Preferred Project Report

166 - 174 Hawkesbury Road, Westmead
Westmead Millennium Institute and
Westmead Research Hub

Submitted to
Department of Planning
On Behalf of Health Infrastructure

December 2010 ■ 09434

SOUTH ELEVATION
DRAWING NUMBER
DA-E-01
ISSUE
6

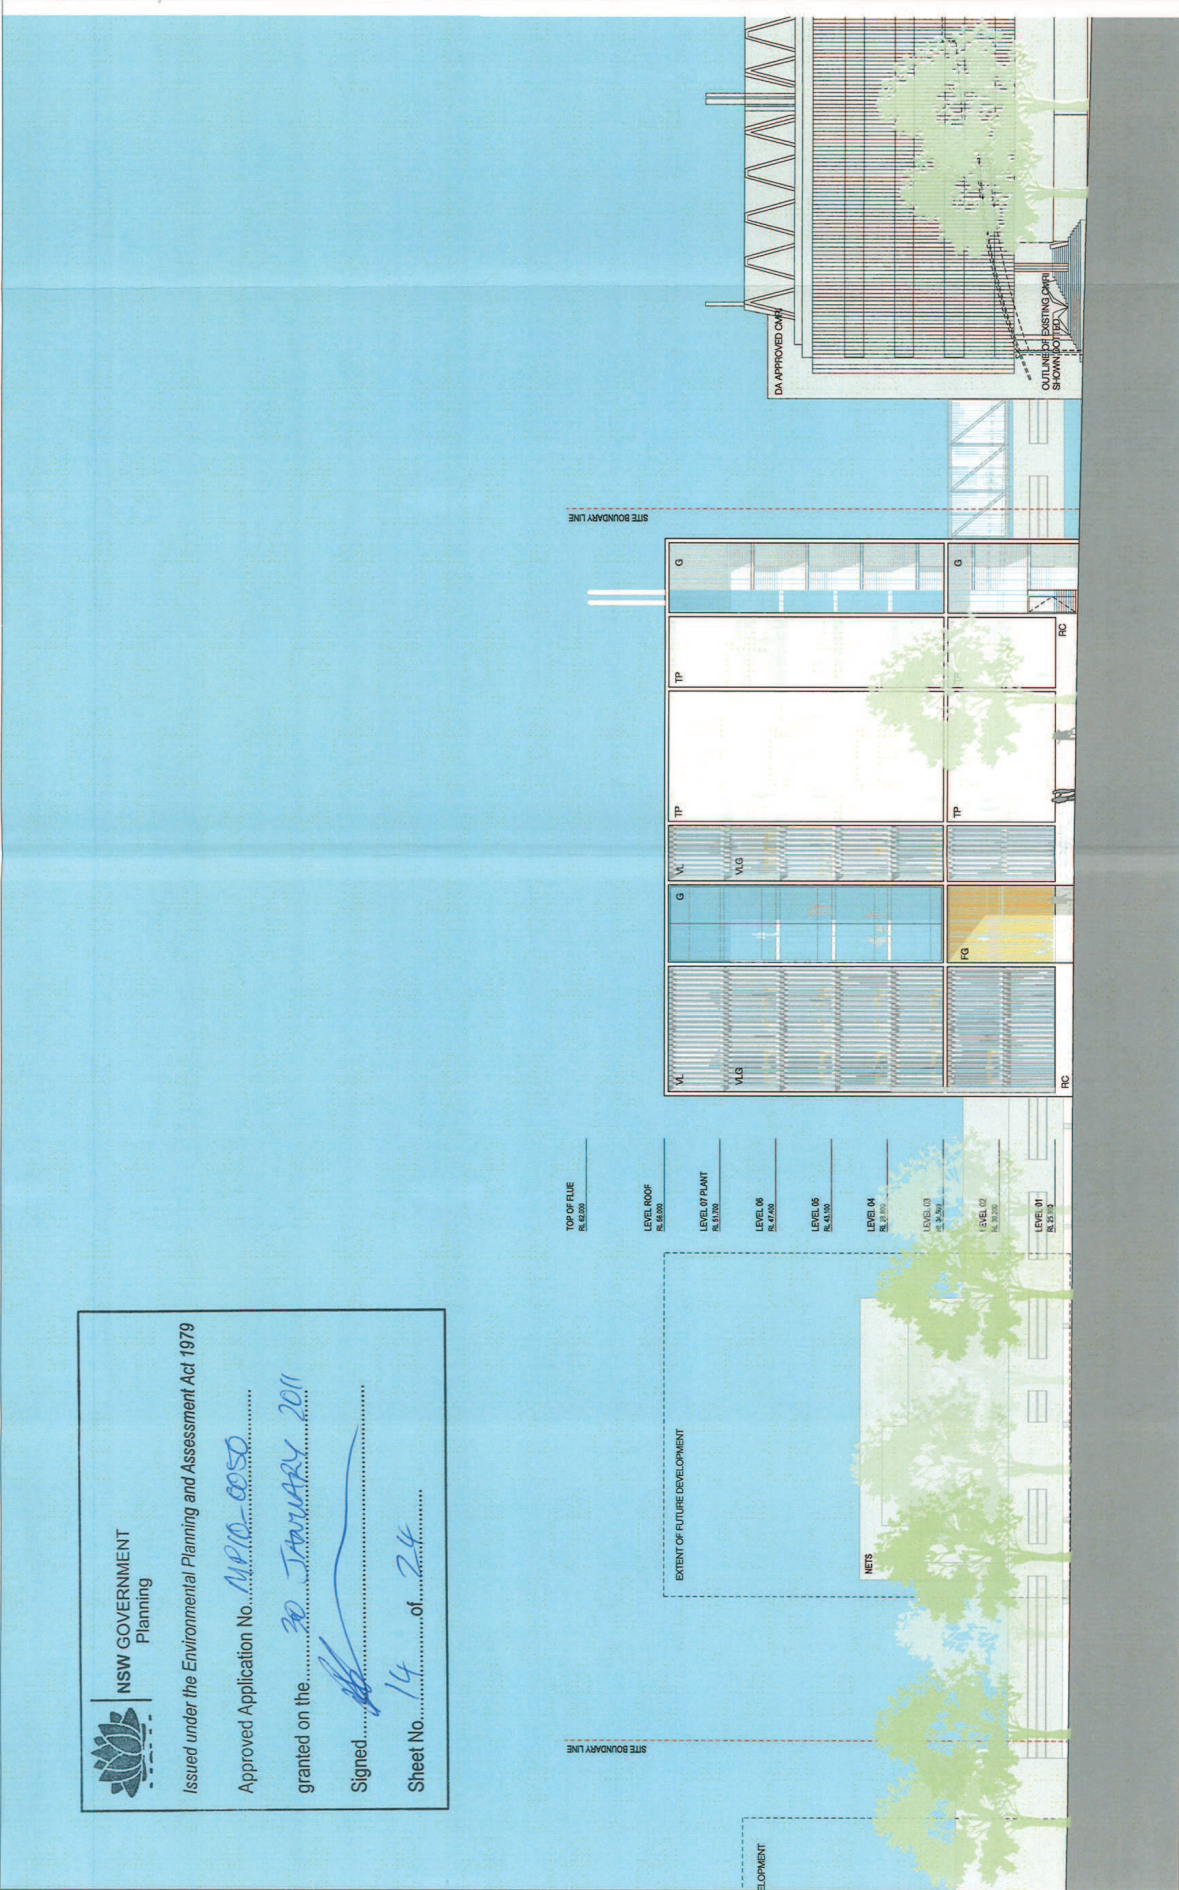
Consideration should be given to setting back the upper levels of the development, to better complement the existing streetscape and scale of the approved CMRI.

The proposed WMI building will be just over one storey (or approximately 6m) higher than the approved CMRI (refer to **Figure 4** below). Whilst likely to be readable within the street, this difference in height is not considered to adversely impact upon the visual quality of the existing/future street or the experience of pedestrians walking along Hawkesbury Road. As illustrated within the photomontage images above, this section of Hawkesbury Road will be framed by large buildings that share a close relationship with the street and which will be clearly identifiable as medical and research related buildings (supporting the precept of 'seeing the science'). This built form character, as noted above, is likely to be ultimately carried through along Hawkesbury Road as part of the planned redevelopment of Westmead Health Campus. In this context, the height difference between the proposed WMI building and the approved CMRI building is considered to be insignificant, and does not adversely affect the desired built form character or streetscape.

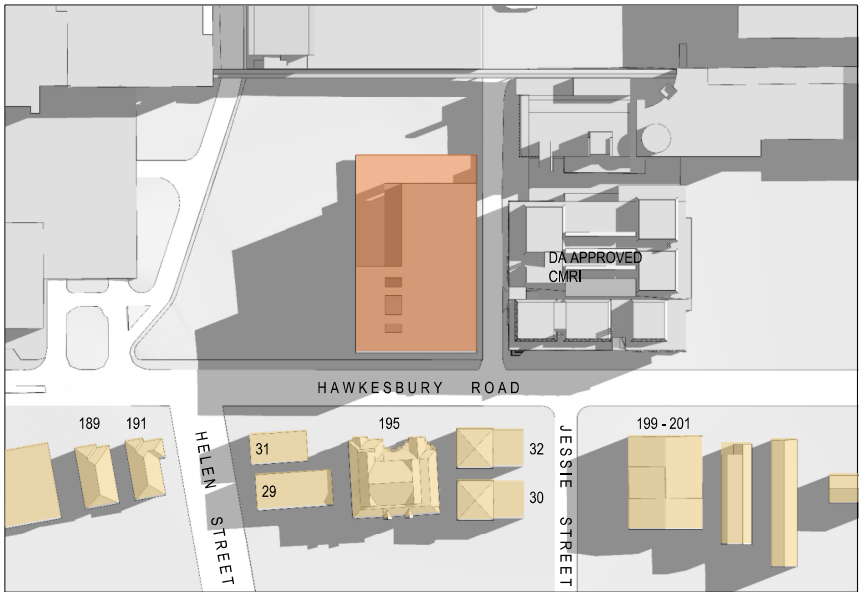
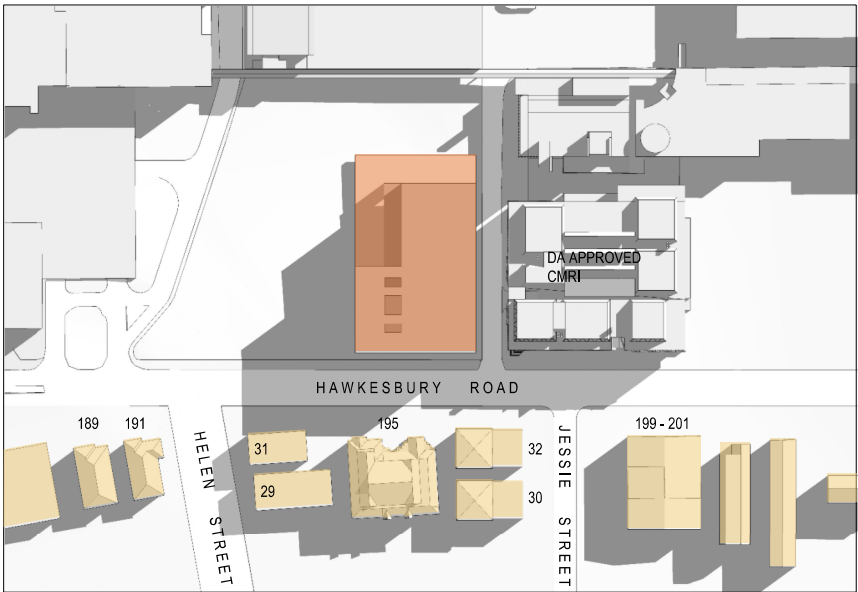
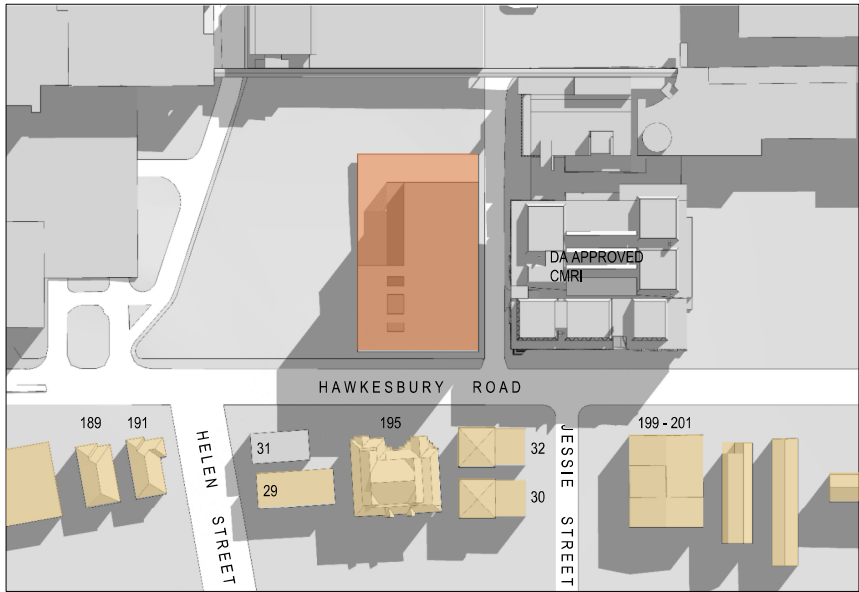
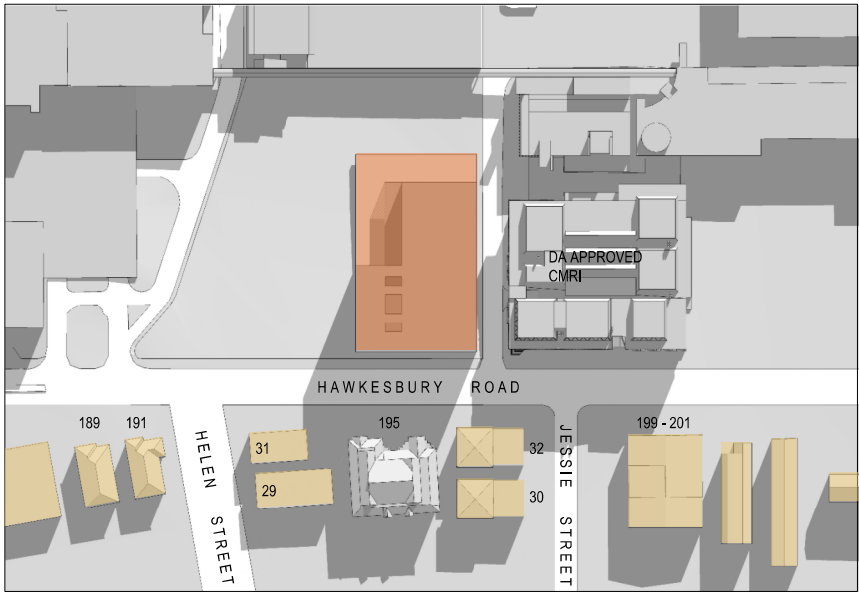
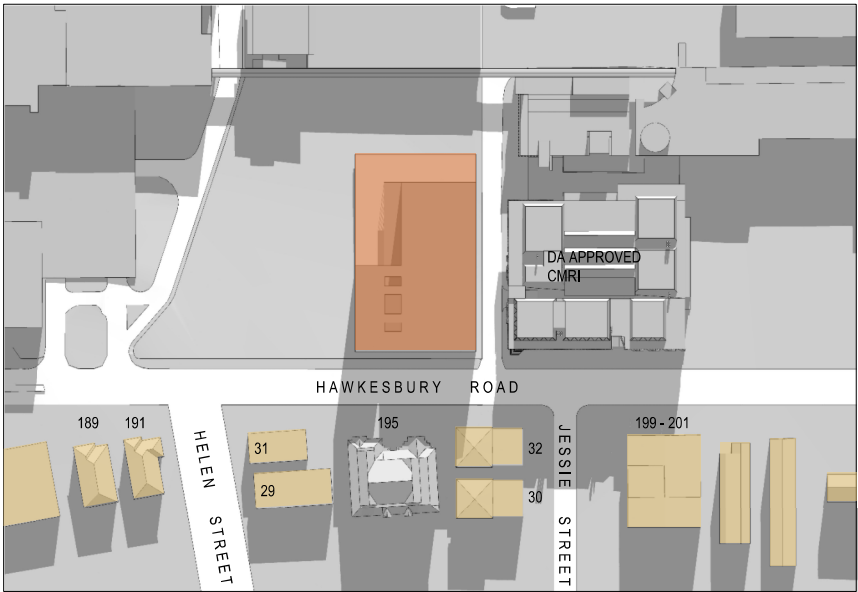
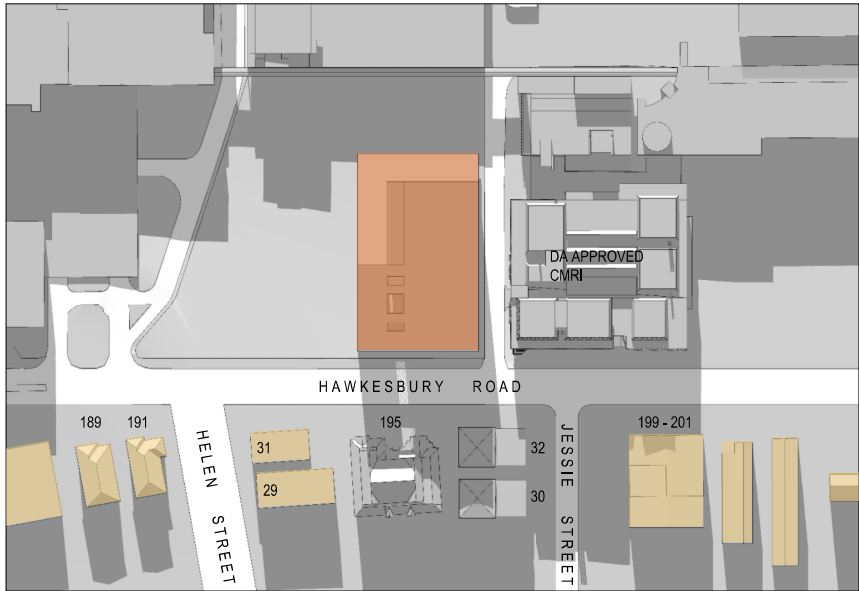
The Environmental Assessment details a level of overshadowing impacts on the existing residential flat buildings to the southeast of the proposed development. Additional shadow diagrams are requested detailing hourly overshadowing from the proposal.

The EAR addresses Solar Access and Overshadowing at Section 5.4. As requested, additional hourly shadow diagrams have been prepared by BVN Architecture (refer to **Appendix B**).

Both perspective and plan view diagrams have been prepared illustrating hourly overshadowing caused by the proposed development. **Table 1** below provides a summary of the resulting hourly overshadowing impacts caused by the proposed development. Importantly, and in accordance with SEPP 65, all surrounding residential apartments will receive a minimum of at least 3 hours of direct sunlight between the hours of 9am and 3pm in mid winter. All residential apartments (including front balconies) at 195 Hawkesbury Road for example will receive direct access to sunlight at 9am, 10am, and 11am, with only minor overshadowing to one balcony occurring at midday.
